SCHEDULE OF CHANGES TO THE DRAFT DCO

HyNet Carbon Dioxide Pipeline DCO

Document Reference Number D.3.3

Table of Amendments to the Draft Development Consent Order – Deadline 8 (Revision K from Revision I)

EN070007-D.2.5-AROW-Sheet 19

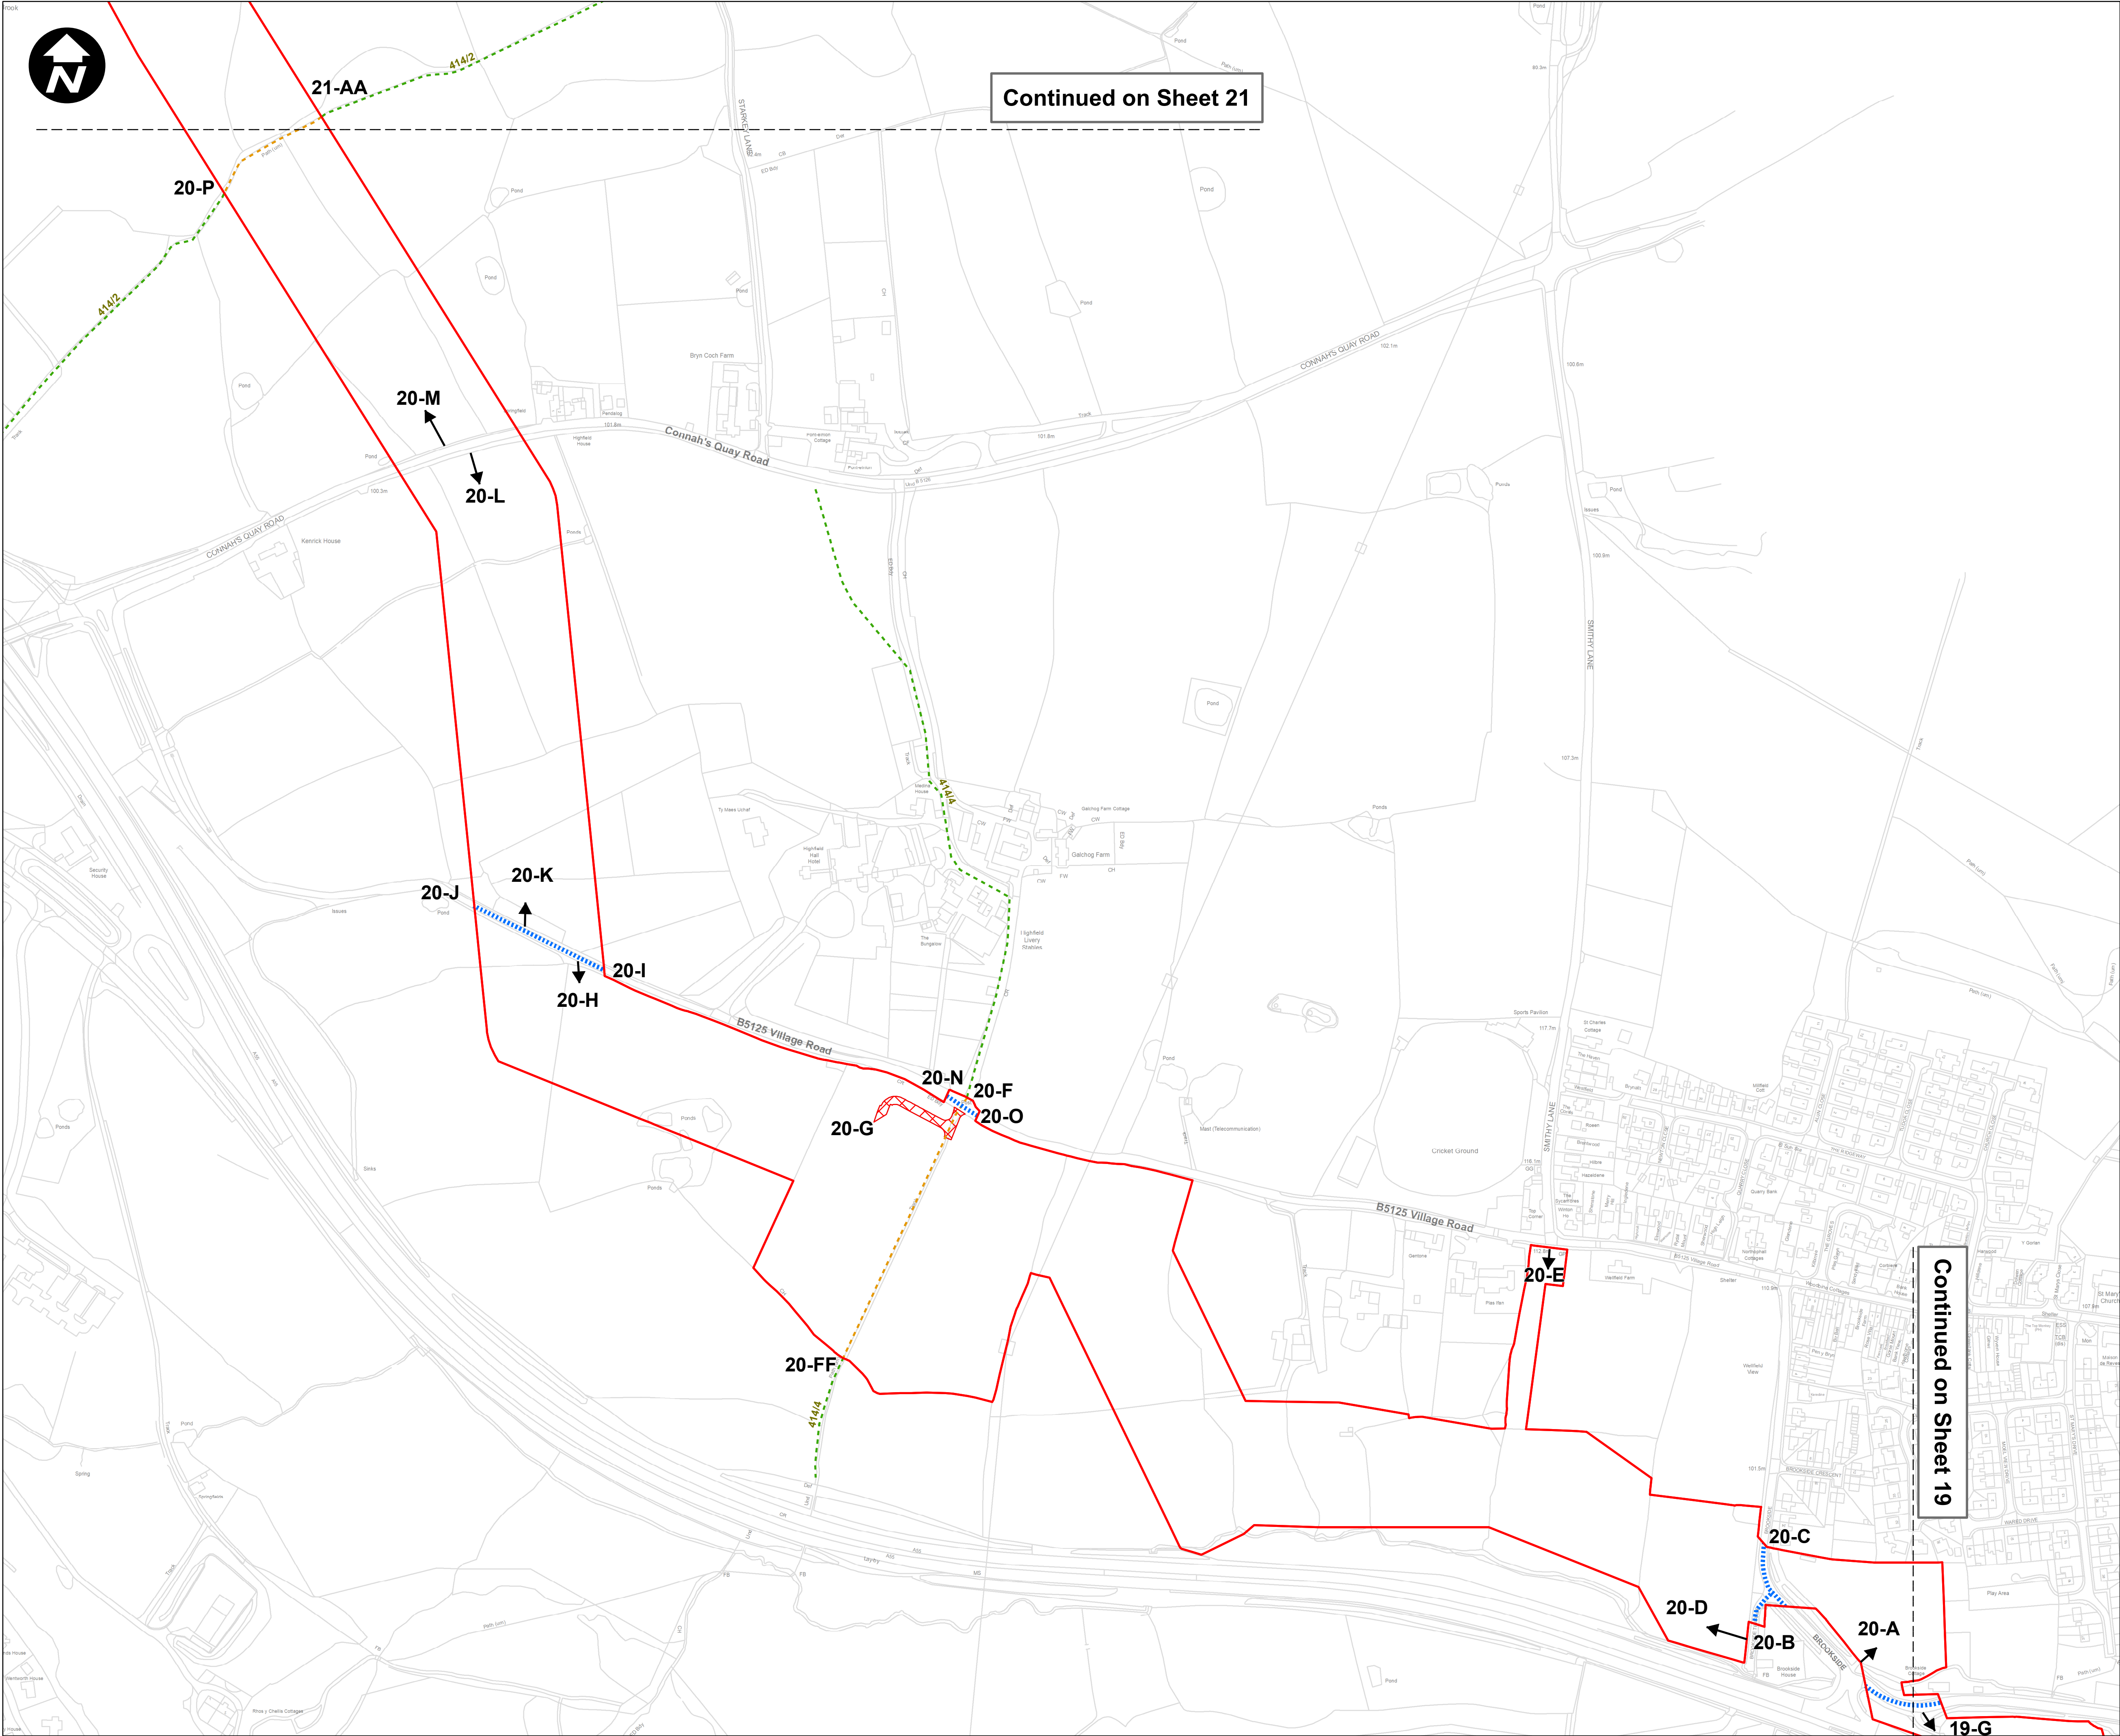
In the County of Flintshire	Footpath 414/39A	Between the points marked 19-D and 19-DD on sheet 19 of the access and rights of way plans shown with a dashed purple line	Between the points marked 19-D and 19-DD on sheet 19 of the access and rights of way plans	
Schedule 10 protective provisions	Amendment to all parts other than parts 1 and 2.				Please see detailed explanation of the status of the protective provisions in the Applicant's deadline 7 submission document D.7.62, DCO drafting update.
